### It is unclear what is being applied for

### Four storeys, the thin end of the wedge

Detail
PLANNING LAYOUT - PLOTS 23, 34/35

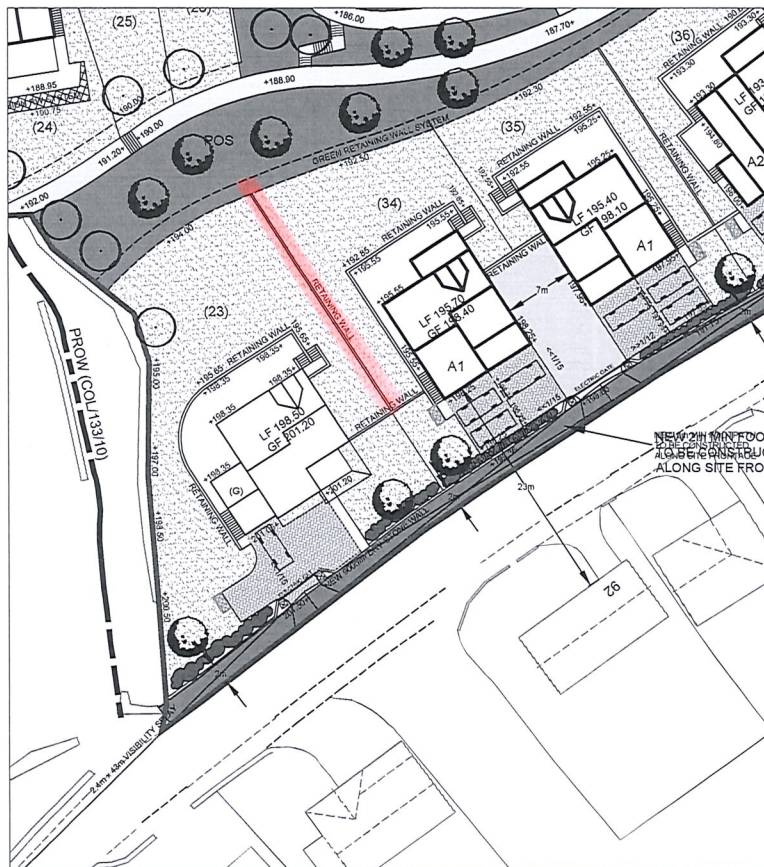
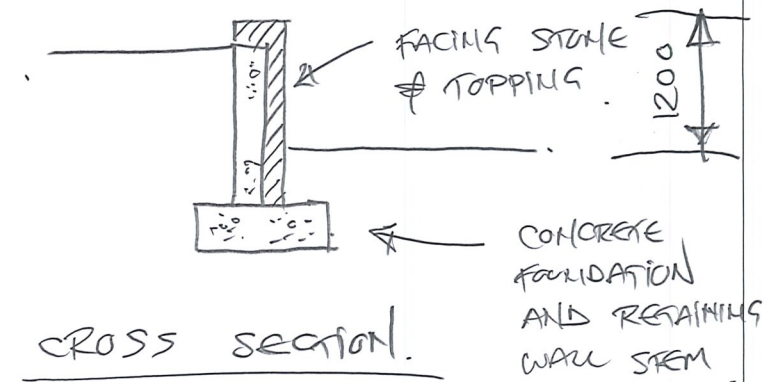
I do not agree with these dwellings being made four storey. I believe that would result in changes throughout the site that means they majority of the development will then be made the same. I see the developer is already lifting the ground level, across the site, such that everything appears to sit a lot higher than it ought to have. I fear, allowing four storeys will just make the raised elevations more evident. I am also concerned that roads, and parking bays will also be elevated. Just looking at the turning head that is in the process of being built, facing the farm, it is ridiculously high in comparison to the farm's existing garden level. To me the turning head is just appalling. From memory, the Local Plan talks about new development fitting in. How can this be said to do that. It is not subtle, and hits you in the face. Concrete truck, after truck, keep turning up, filling it with concrete. There is so much concrete it is ridiculous.

The way the applicant's narrative reads, for plot 23, in my opinion, it is asking the reader to sympathise with the needs of the potential residents. That, without allowing a fourth storey to be permitted, the house would not be good enough for them. By objecting, my interpretation is, we would be denying them something they really need; three storeys are insufficient; and it would be mean to deny them a fourth. Yet, I am aware the UK national average, of students having free school meals, is 24.6%. But, one local school has a figure that is nearly 50%. Some students attend local schools wearing trainers, which are then swapped for shoes, each day, which the school provide, to allow those students to meet uniform standards. I also know there are local children that have to sleep on sofas, their homes having insufficient bedrooms. Why am I mentioning this? It is because these facts speak to the needs of the local area, where £899k houses seem obscene. Offering what I see as a sob storey, to justify a fourth storey, seems distasteful. If approved, I fear future developments would automatically see four storeys being applied for, with this one as justification for allowing it. There are no four storeys locally, and I believe this application should be judged against that, not a sob story.
